ITEM 4.1 (a)

Issue/ Objection:
Car Parking

85 Harrington Street
The Rocks
GOLDEN AGE & HANNAS THE ROCKS

TITLE
**RESPONSE TO DoPE
ITEM 4.1 (a)**

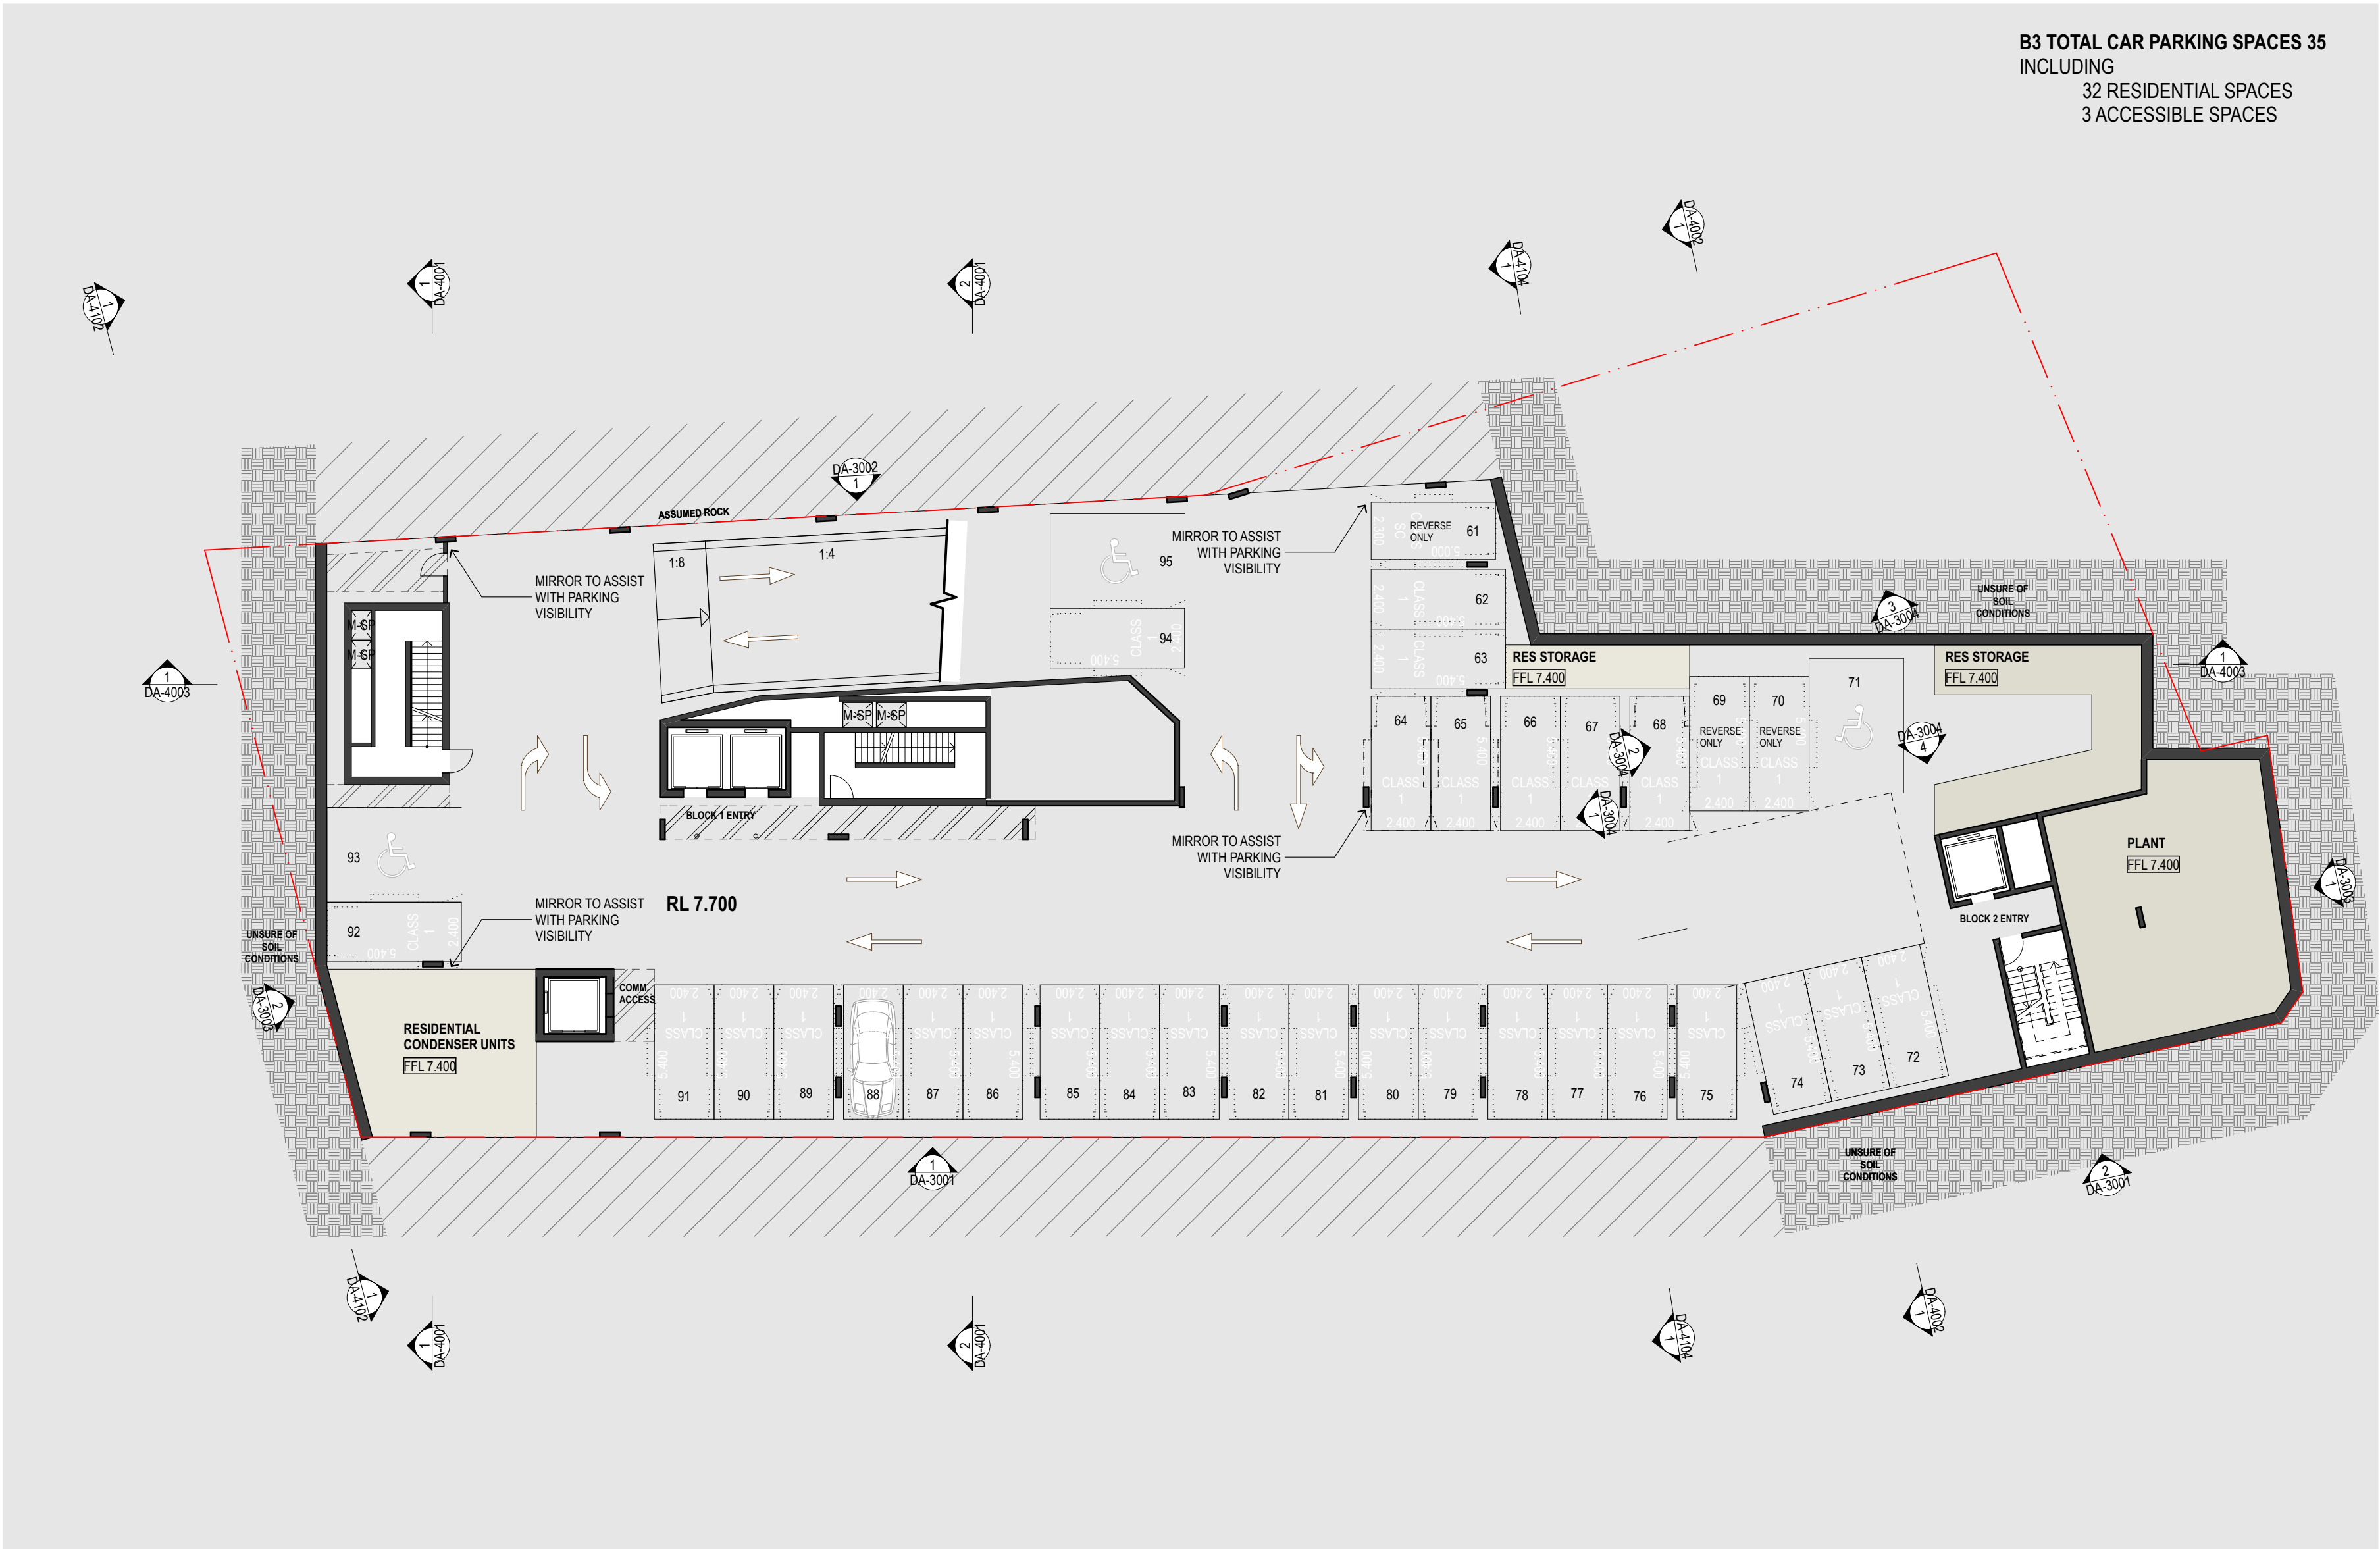
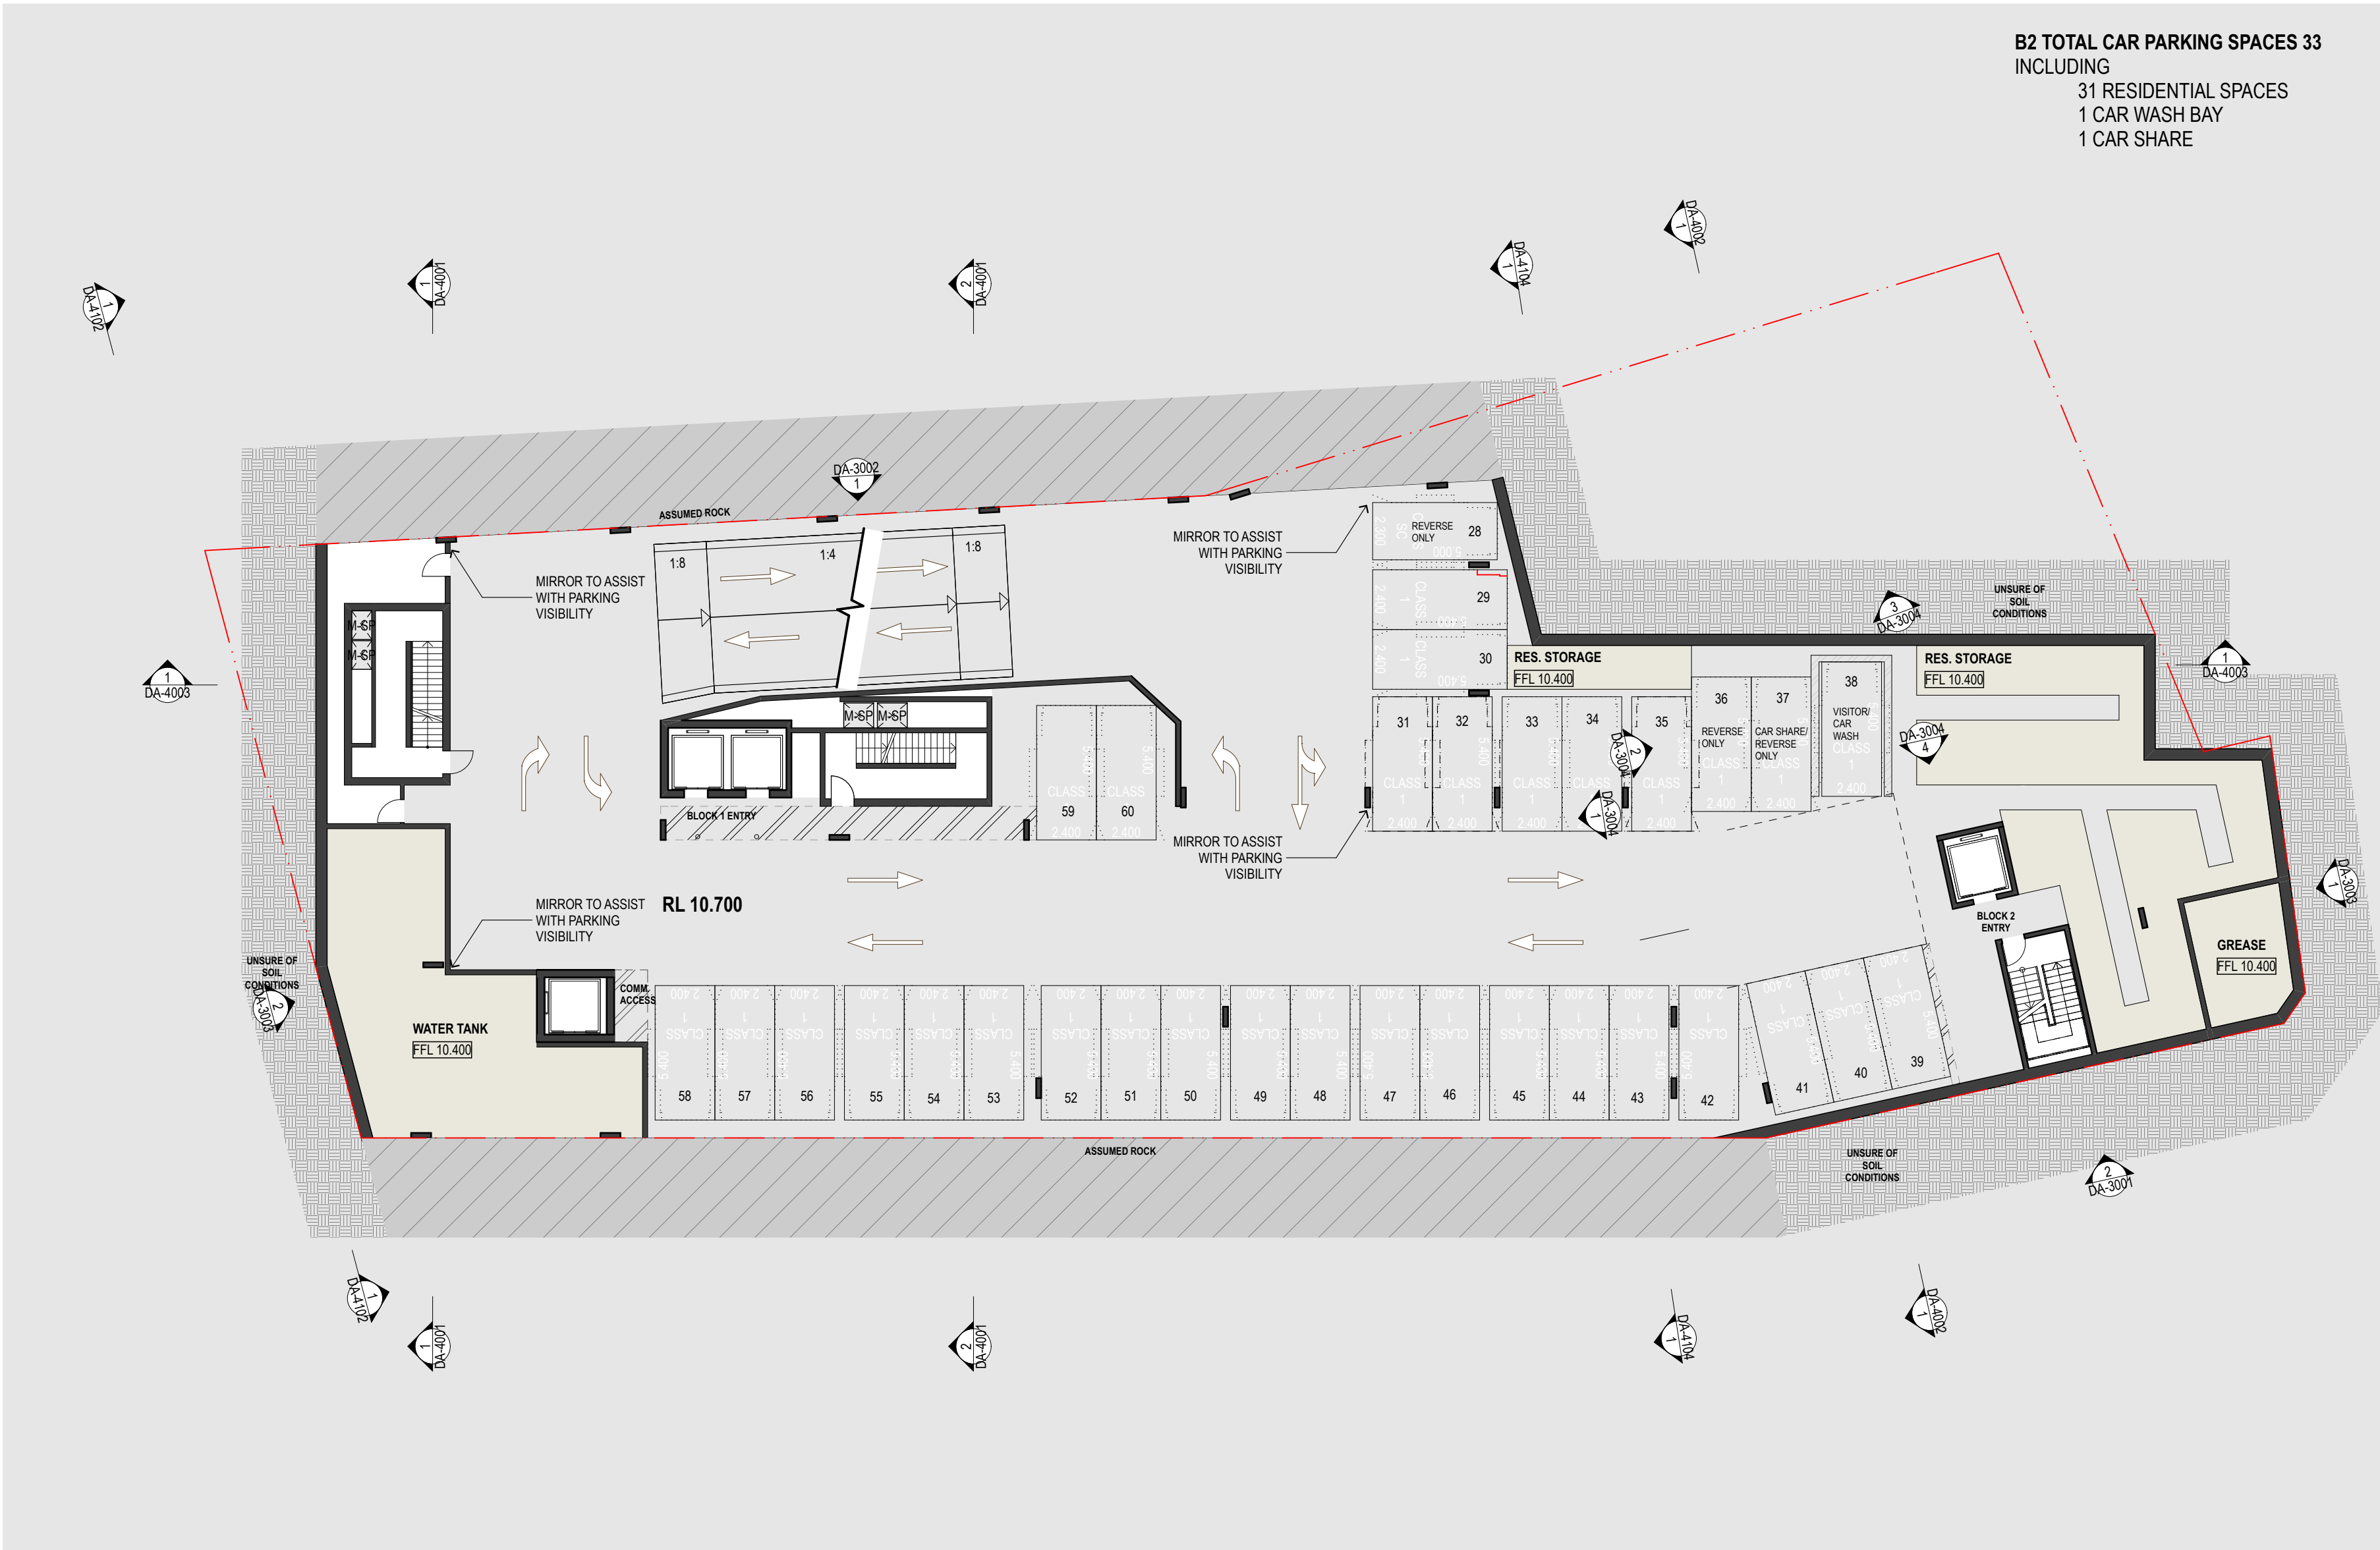
Description:
Given the location of the site within the CBD and close proximity to a variety of public transport nodes, consideration should be given to further rationalisation of the proposed number of residential car parking spaces.

Response
Refer to drawings and report provided by the traffic consultant.
